Application Ref:	3/2025/0324			 Ribble Valley Borough Council <hr/> www.ribblevalley.gov.uk
Date Inspected:	13/05/2025	Site Notice:	28/05/2025	
Officer:	MC			
DELEGATED ITEM FILE REPORT:				APPROVAL

Development Description:	Planning Permission for replacement of rear porch, external steps and railings.
Site Address/Location:	12 Higher Road Longridge PR3 3SX

Title **Proposed Plans & Elevations**

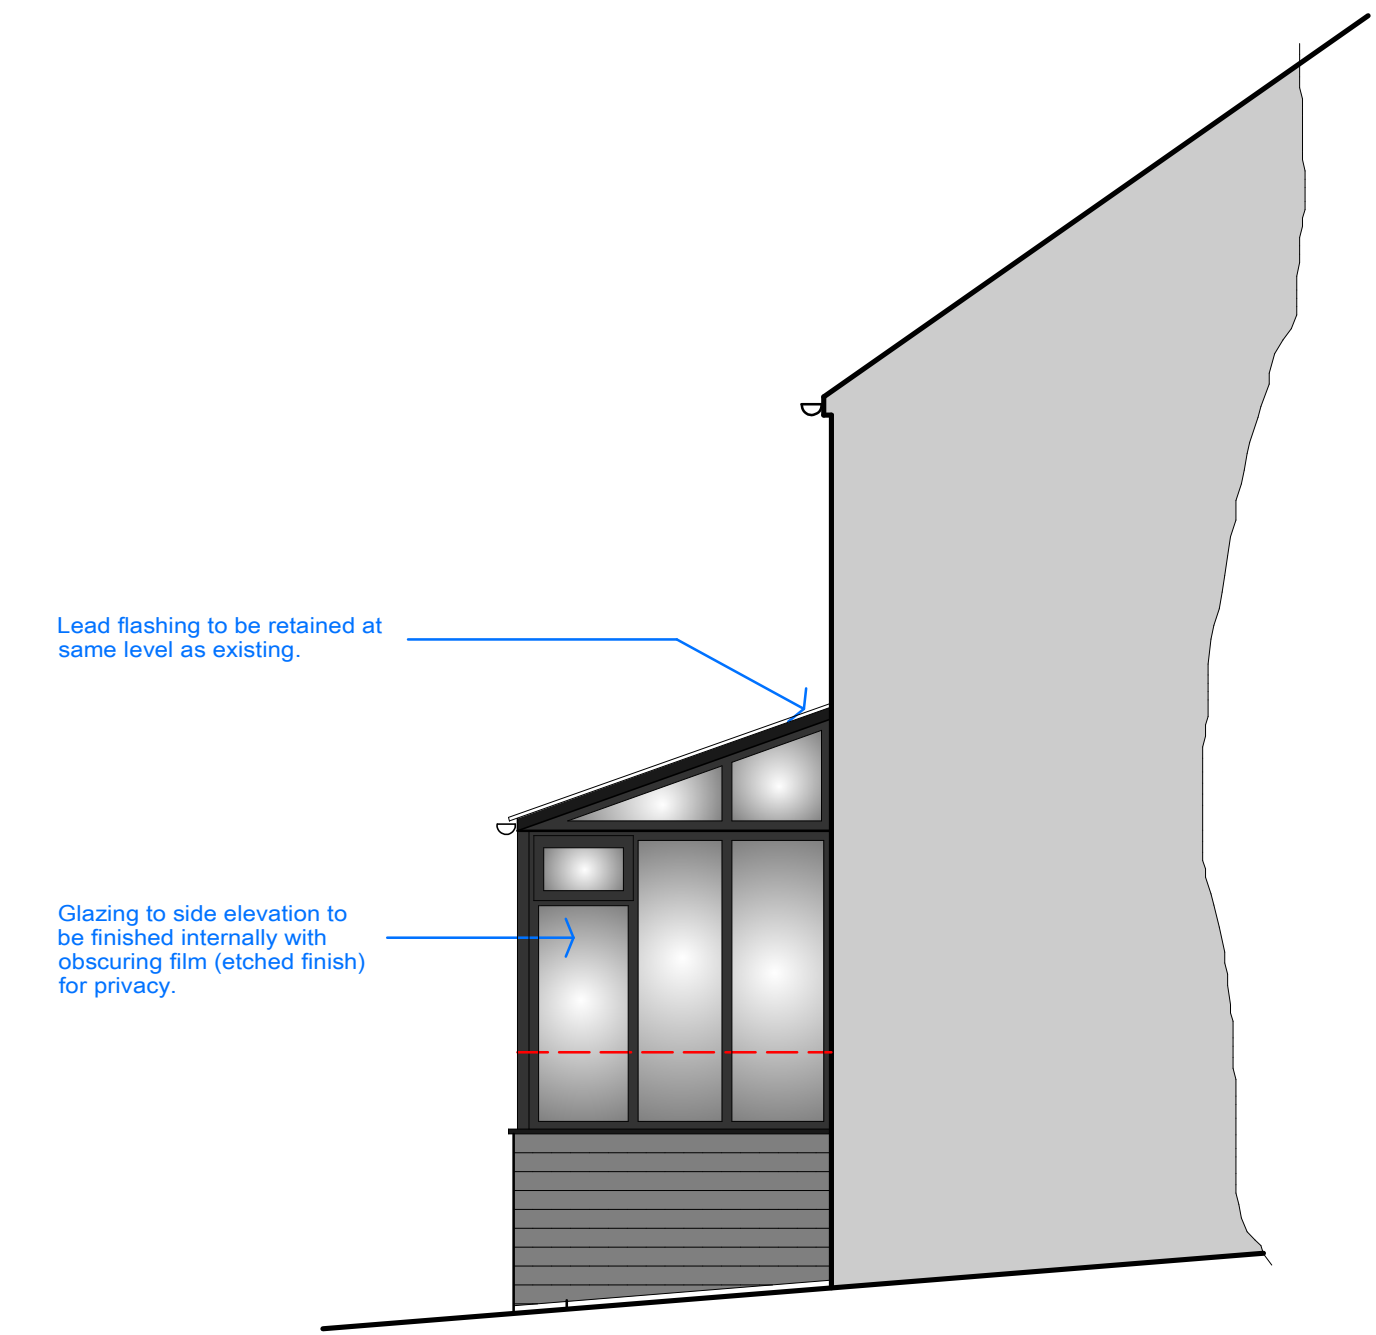
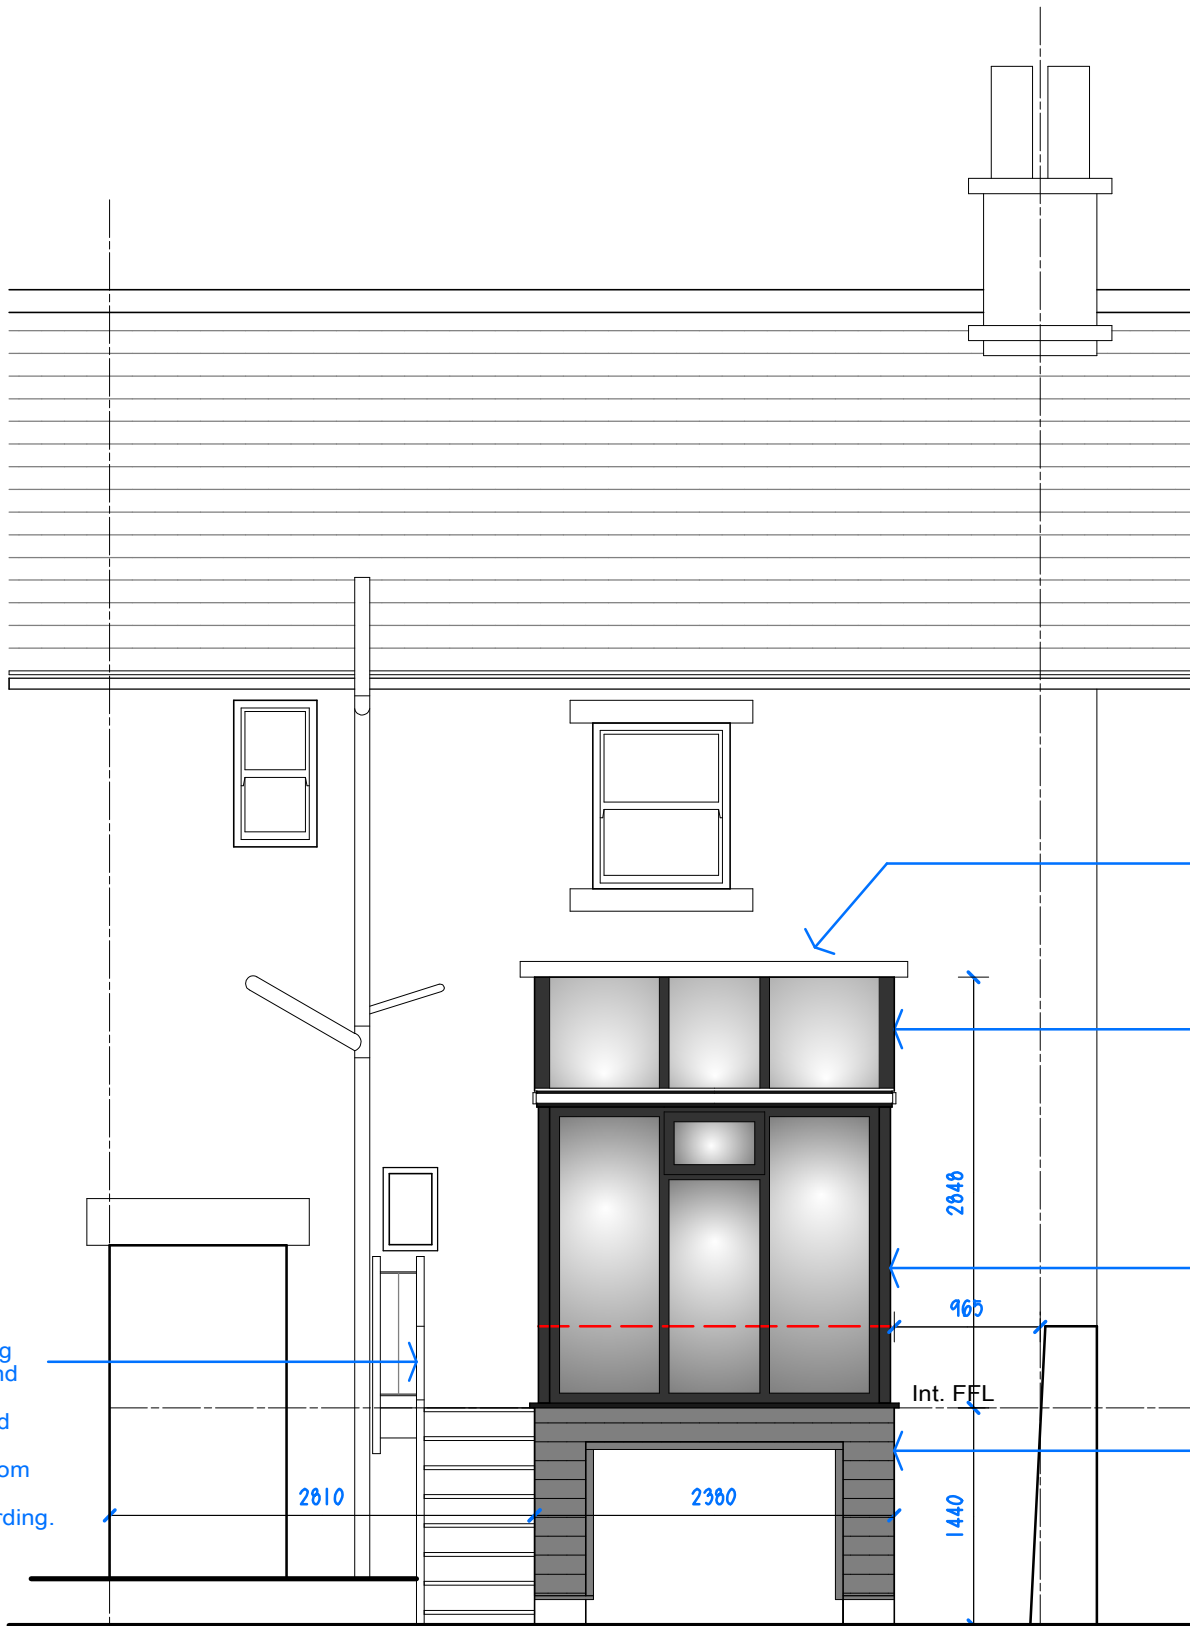
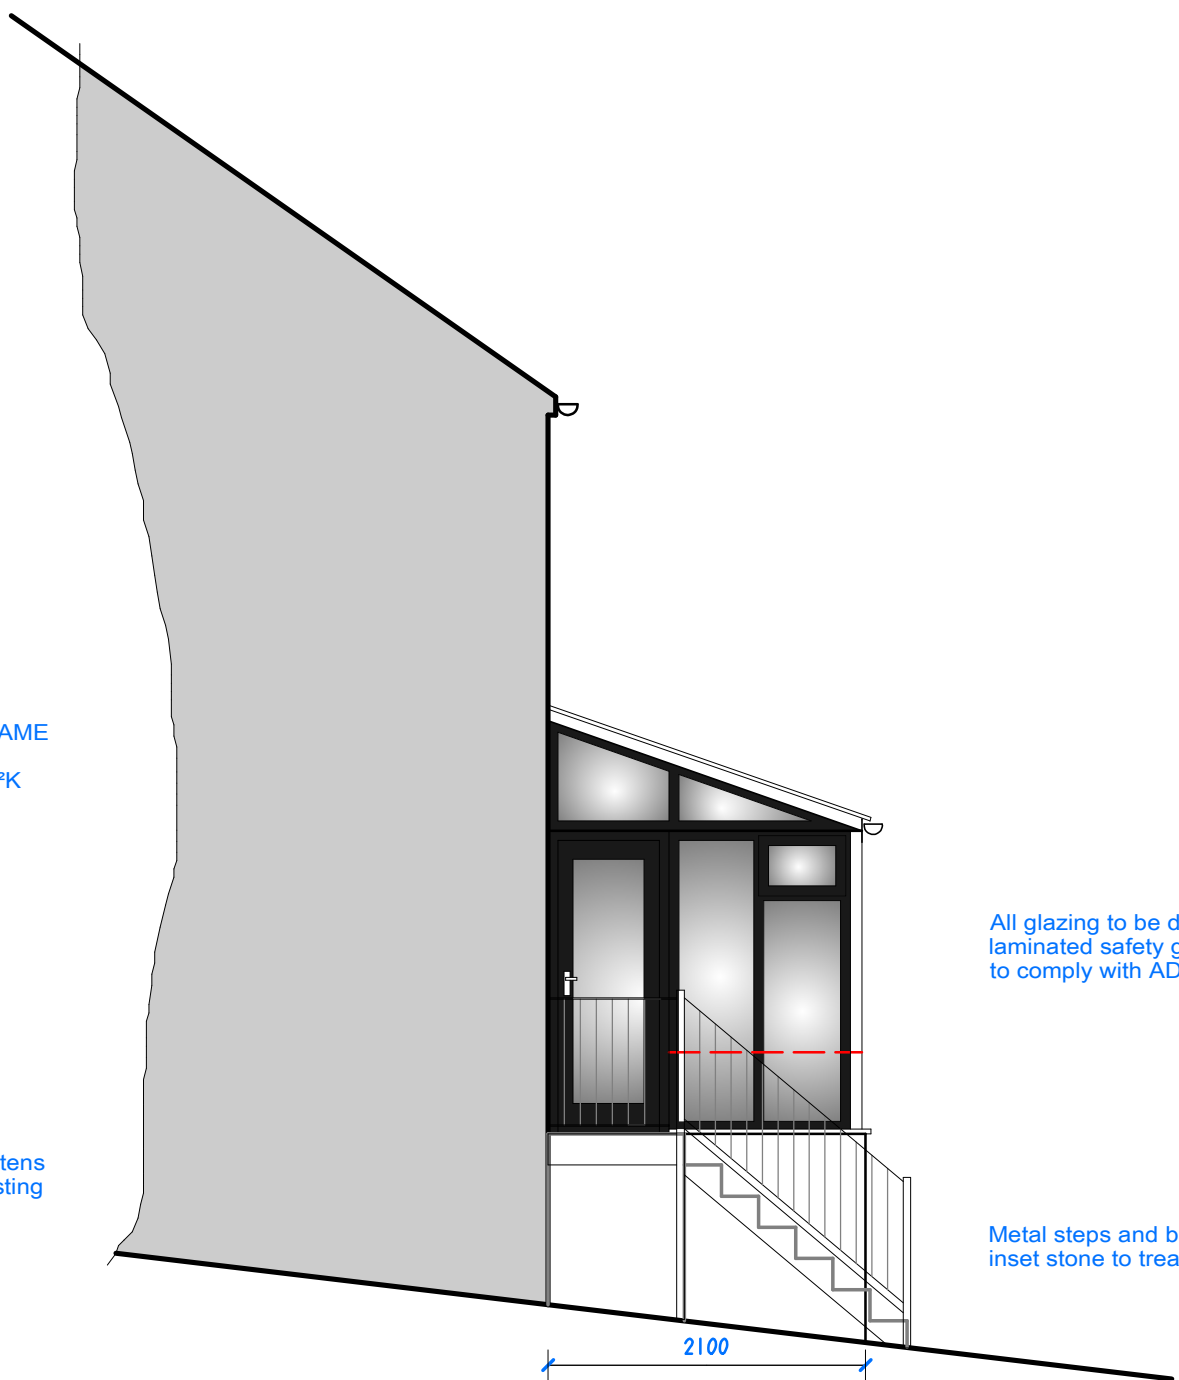
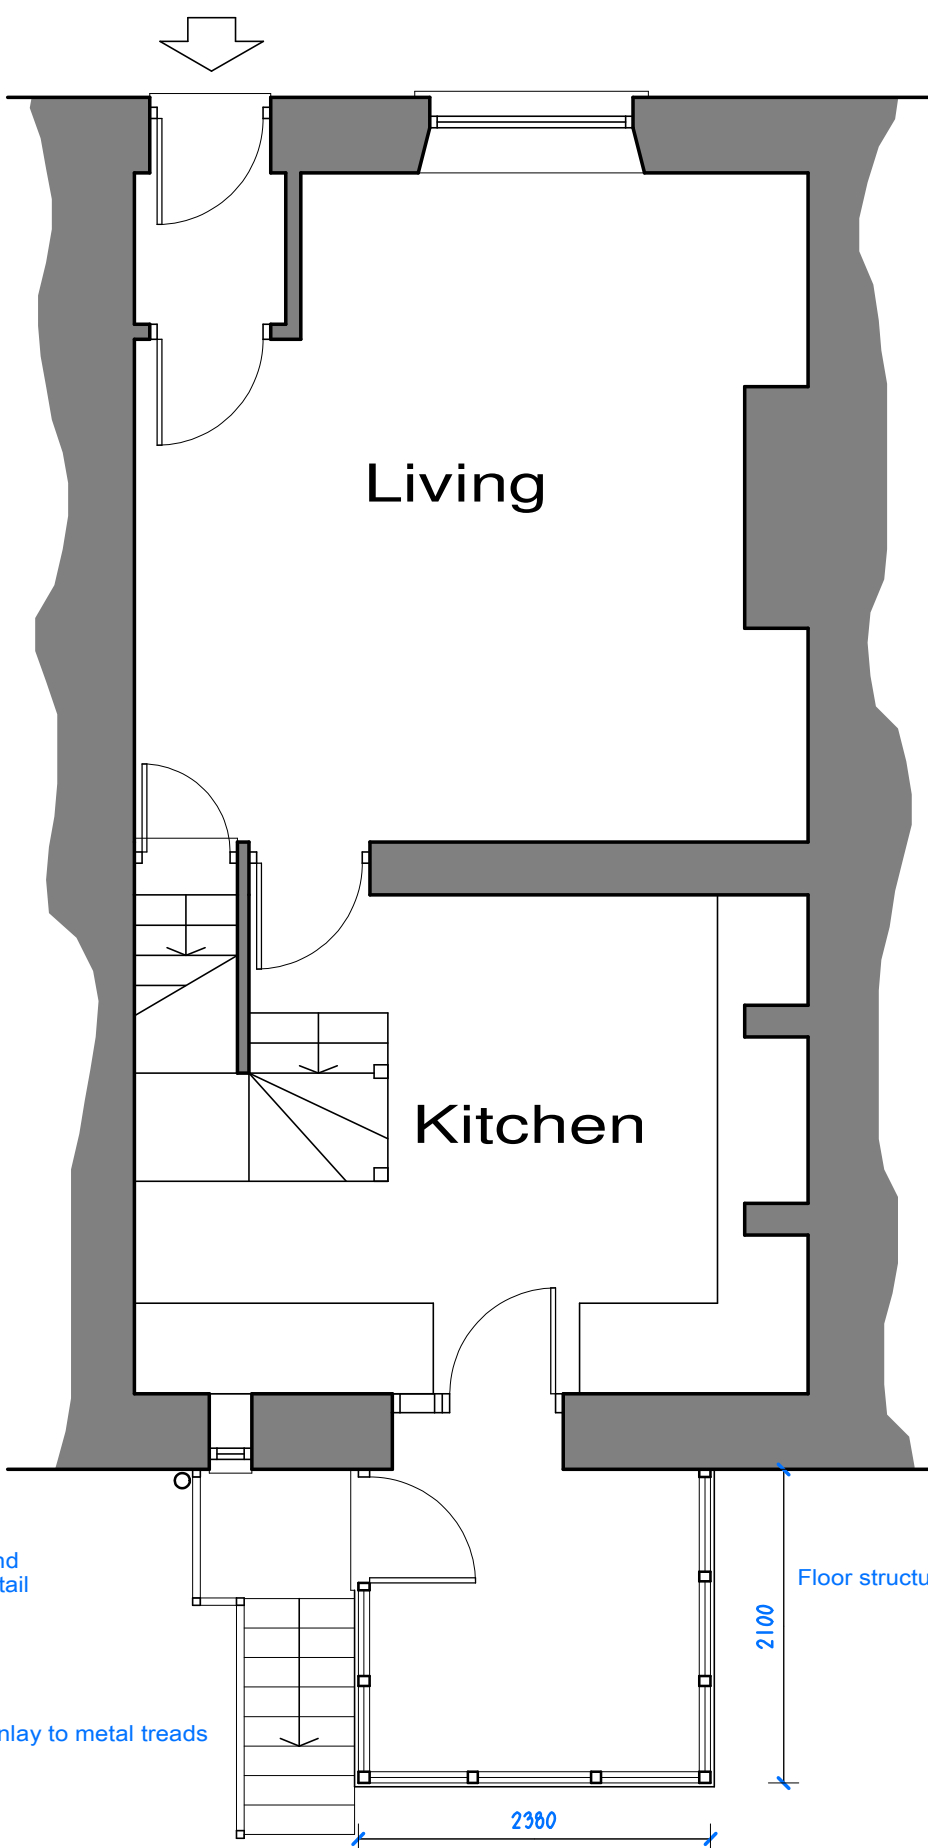
The applicant has installed a netting to prevent any direct overlooking into the primary living accommodation of the adjoining property. The submitted plans indicate that the windows which adjoins number 14 would be fitted with an internal film with an etched finish, however the Council raise concerns that as this would be installed to an internal window, there would not be any control over whether this is fully installed. Whilst the garden is already somewhat overlooked, due to rear extension being raised in relation to the neighbours' rear garden, it would result in the occupiers gaining a direct view down into the primary living accommodation of no. 14. As such, notwithstanding the details outlined on the approved plans, it is recommended that the windows are obscure glazed and secured by condition to prevent any detrimental overlooking into the neighbouring property.
